**CITY OF ALBUQUERQUE  
PLANNING DEPARTMENT  
April 4, 2007  
DRB Comments**

**PROJECT # 1005460**

**RE: Tract 36B1, M.R.G.C.D. Map #35/sketch**

Sketch Plat

SKETCH PLAT OF
 A portion of
 TRACT 36B1
 M.R.G.C.D. MAP NO. 35
 SITUATE WITHIN
 CITY OF ALBUQUERQUE
 BERNALILLO COUNTY, NEW MEXICO

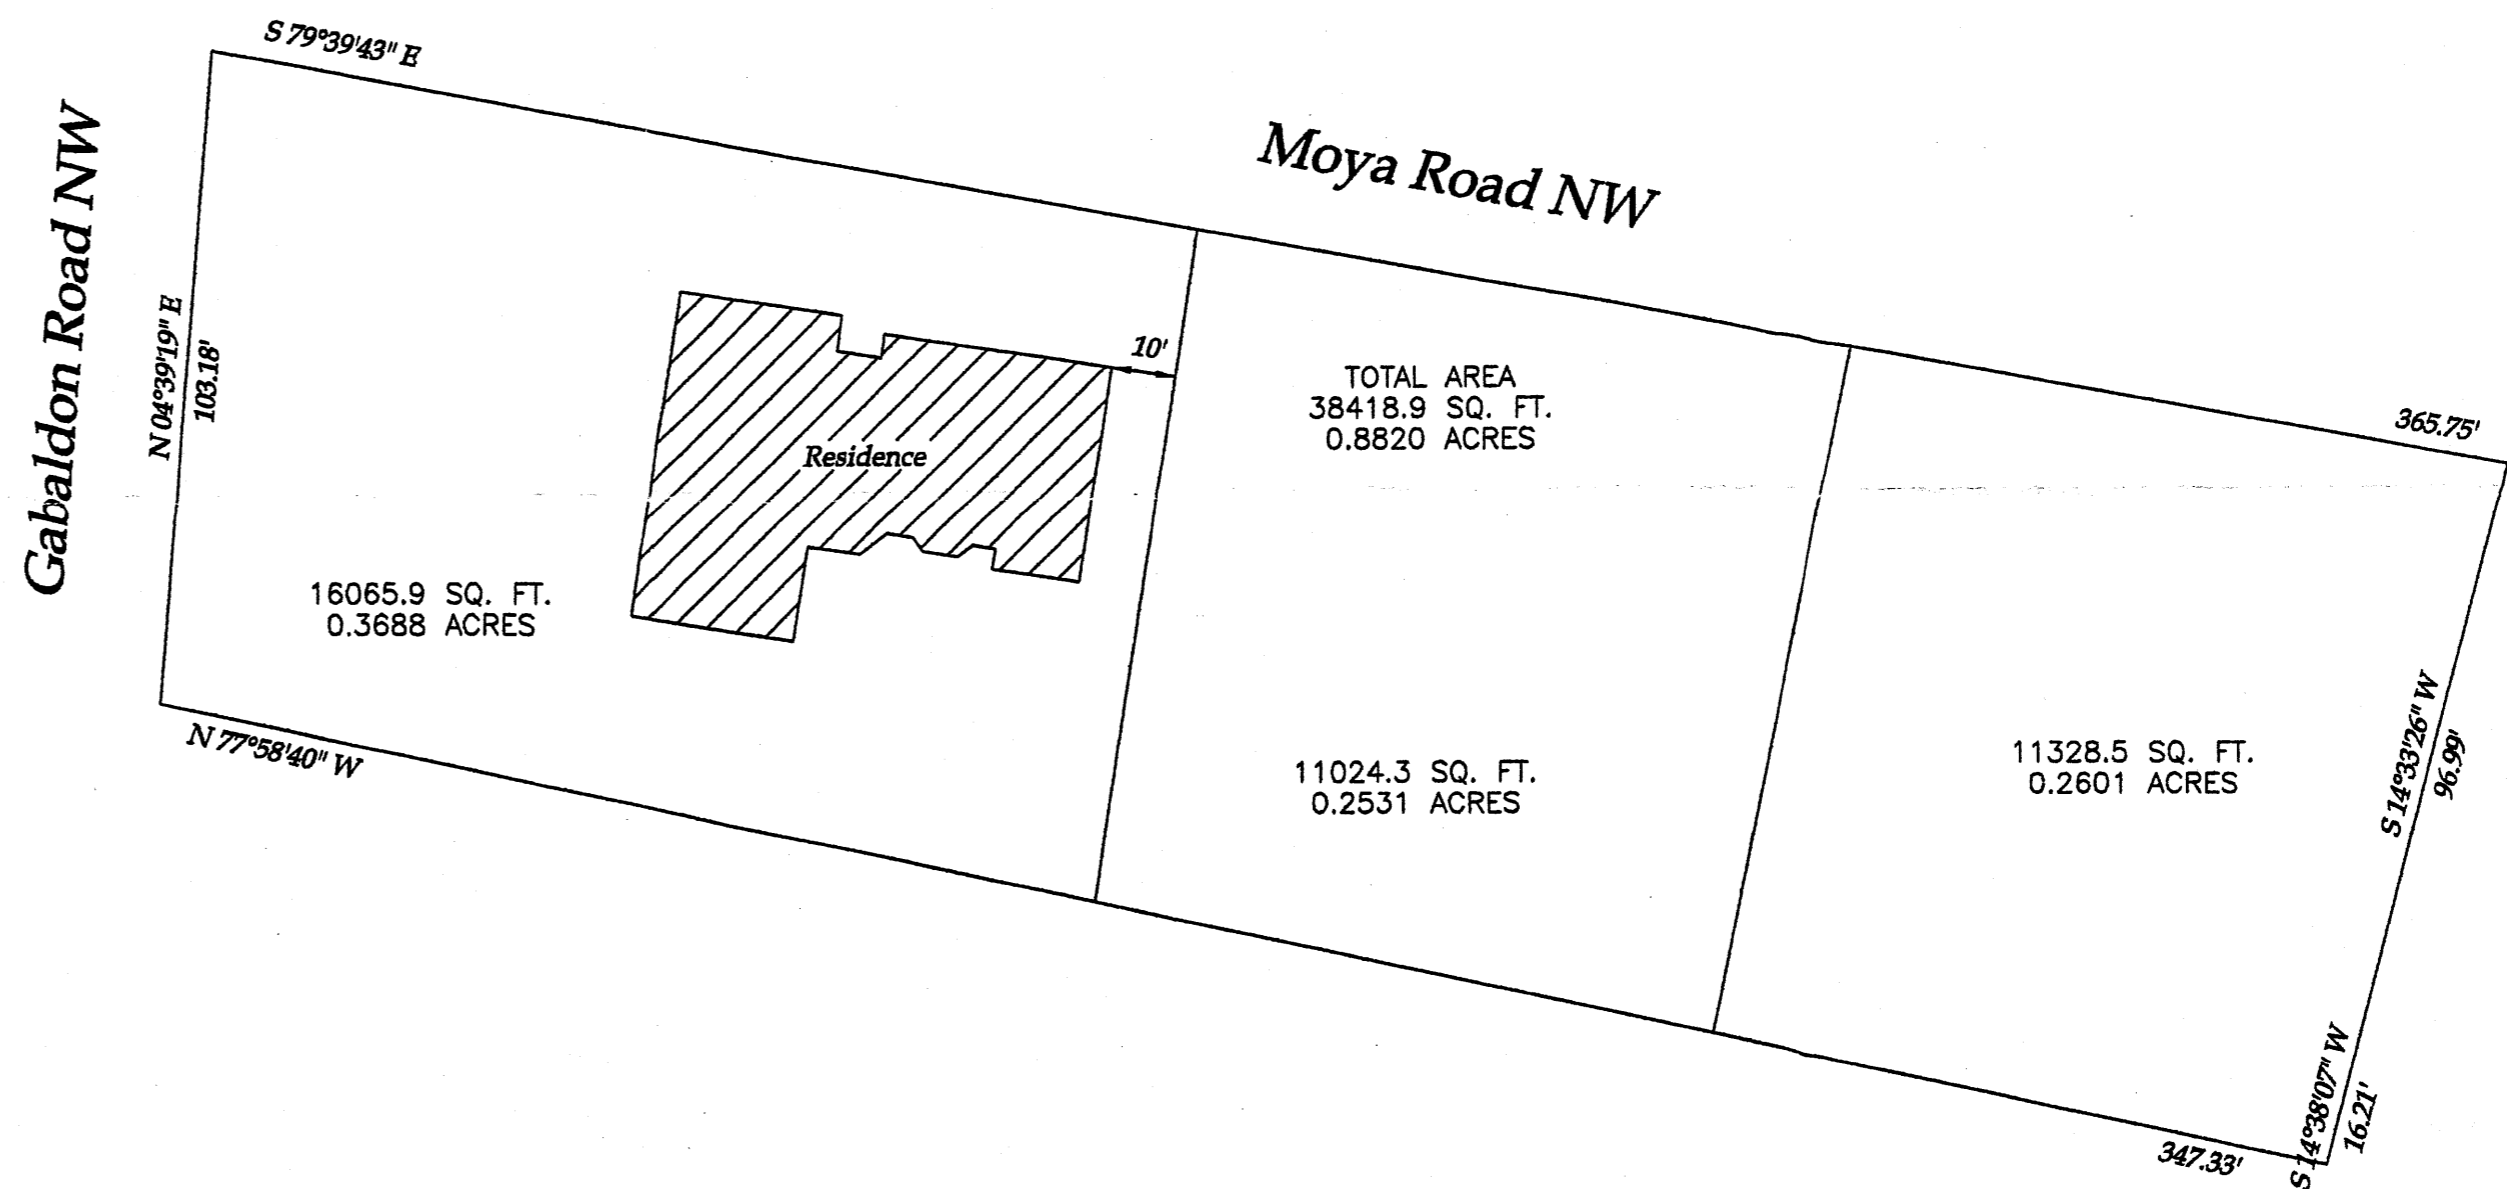
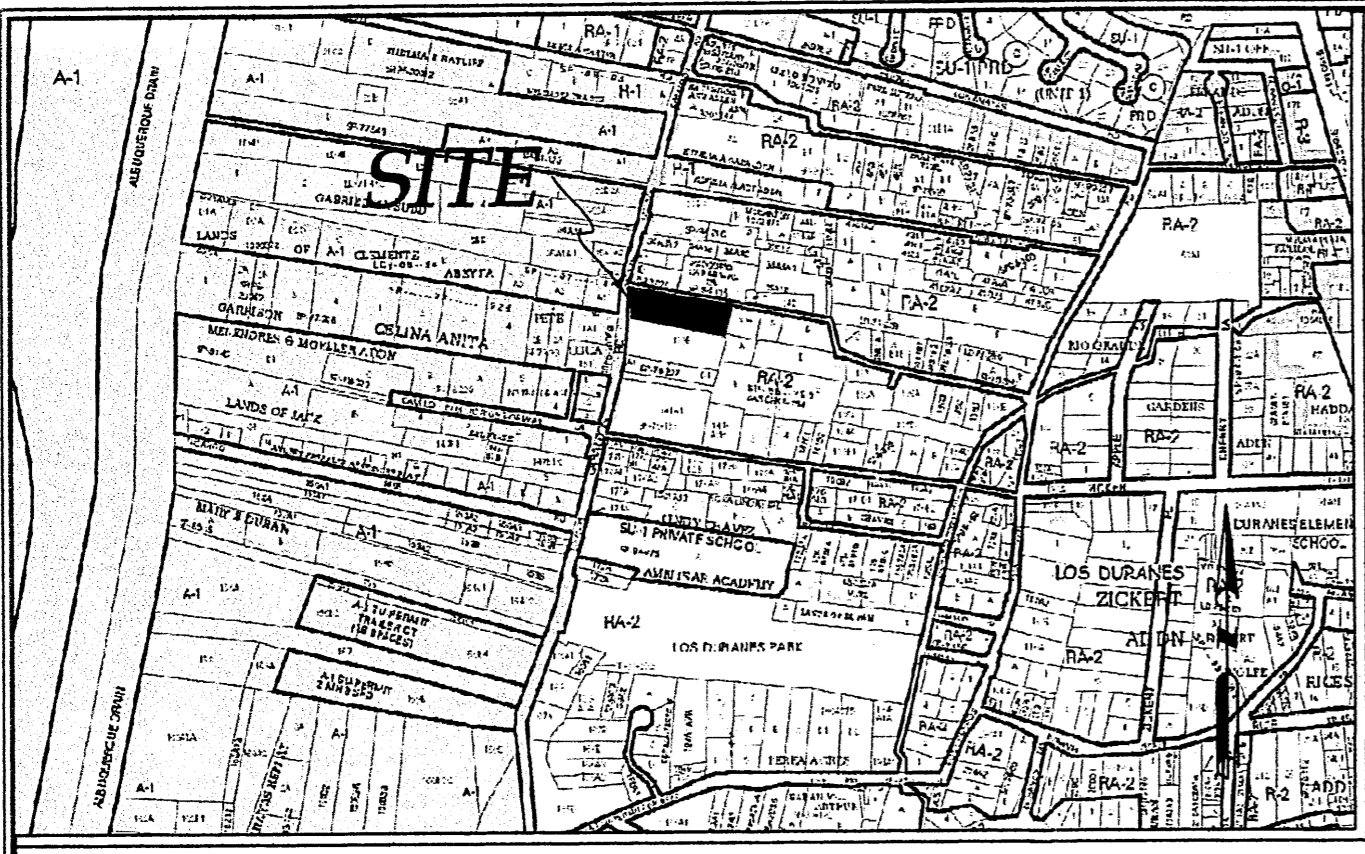
**Where is the access to the interior lots going to be?**

The RA-2 zone in the Comprehensive City of Albuquerque Zoning Code requires a 25 foot rear yard setback.

Need to request a Water/Sewer Availability Statement.  
Water/sewer line extensions will be required.
